KITTITAS COUNTY

MEMORANDUM

TO: All Staff
FROM: Justin Turnbull, County Surveyor 
DATE: May 2, 2018
SUBJECT: County Survey Review of PUD Plat LPF-18-00002 (Evergreen Ridge)

**EVERGREEN RIDGE P.U.D. - PARCEL B, DIVISION 2**  
**A PORTION OF THE NORTH 1/2 OF SECTION 12,**  
**TOWNSHIP 20 NORTH, RANGE 14 EAST, W.M.**  
**KITTITAS COUNTY, STATE OF WASHINGTON**

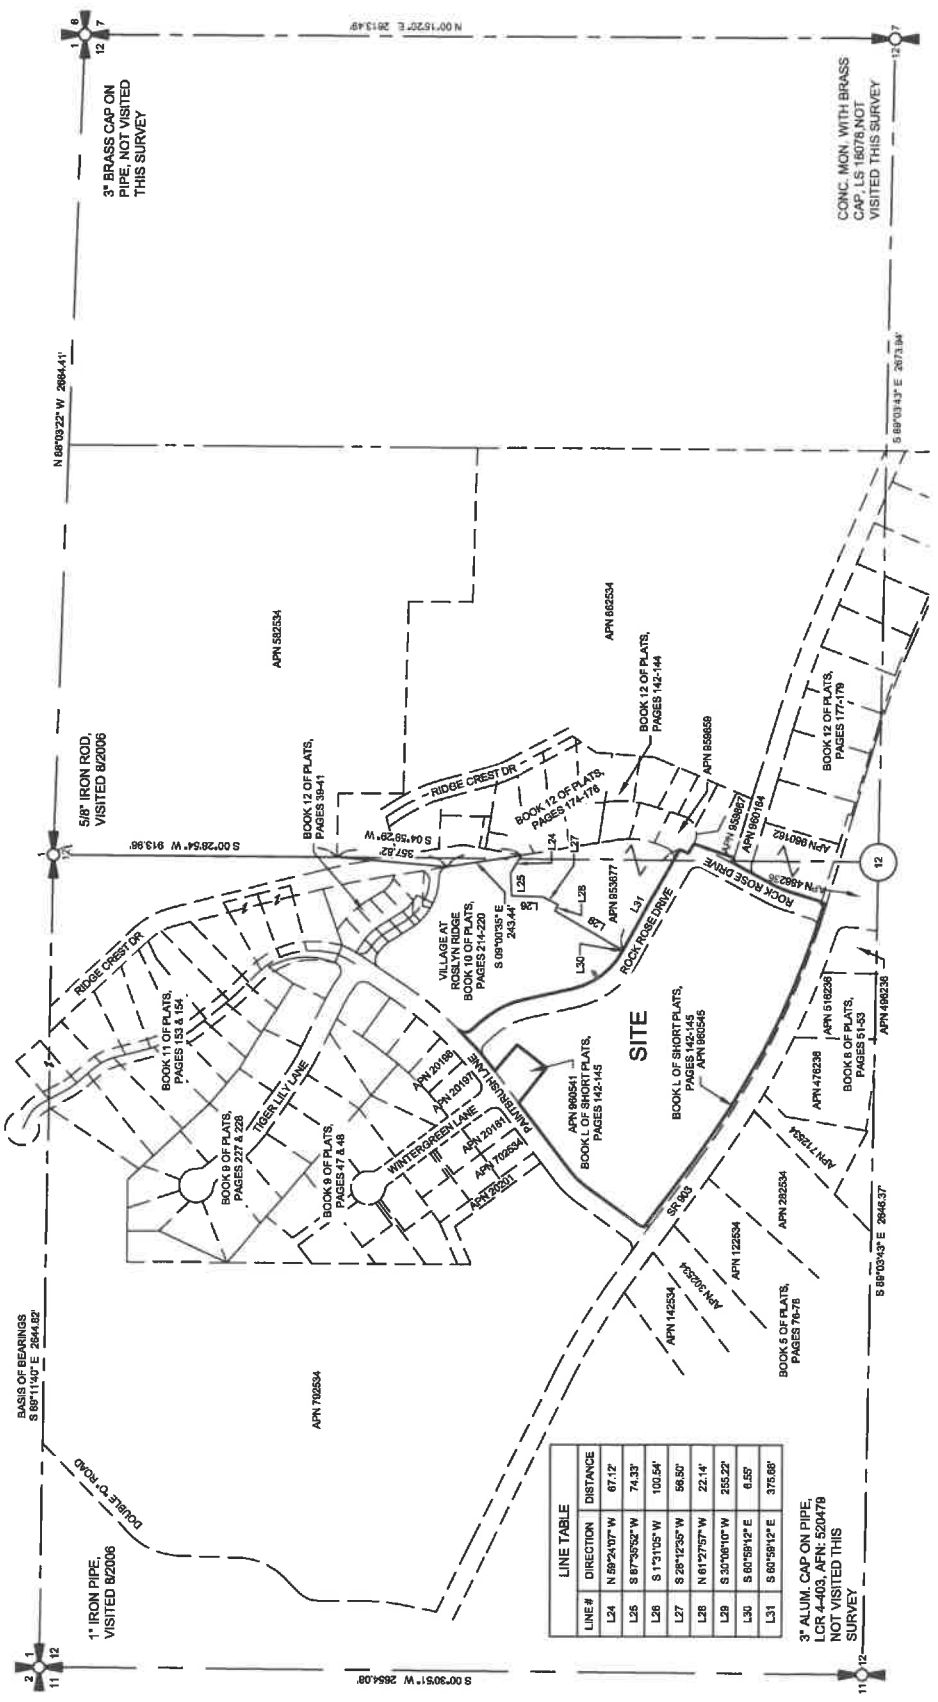
1. Include reference to survey documents that identify difference corner positions.
Along the East line of Paintbrush Lane as it compares to B:9, V:47
214.83' shown, 215.62 of record
Along the North line of Rock Rose Drive as it compares to V:10, B:214 and V:10,
P:185 R=309.74' shown, R=308.00 of record
2. Show Temporary Cul-de Sac on Paintbrush lane (per AFN:201803060001)
3. Show existing buildings on Lots 4A and 4E.
4. Include the Basis of bearing.
5. While not required for preliminary, the final submittal shall include dimensions of the curves of the access easement herein dedicated.
6. The plat notes include conflicting statements as to maintenance responsibilities for the access. Please correct. (Plat notes 5 and 8)
7. Please show the source of the file referenced in plat note 9.
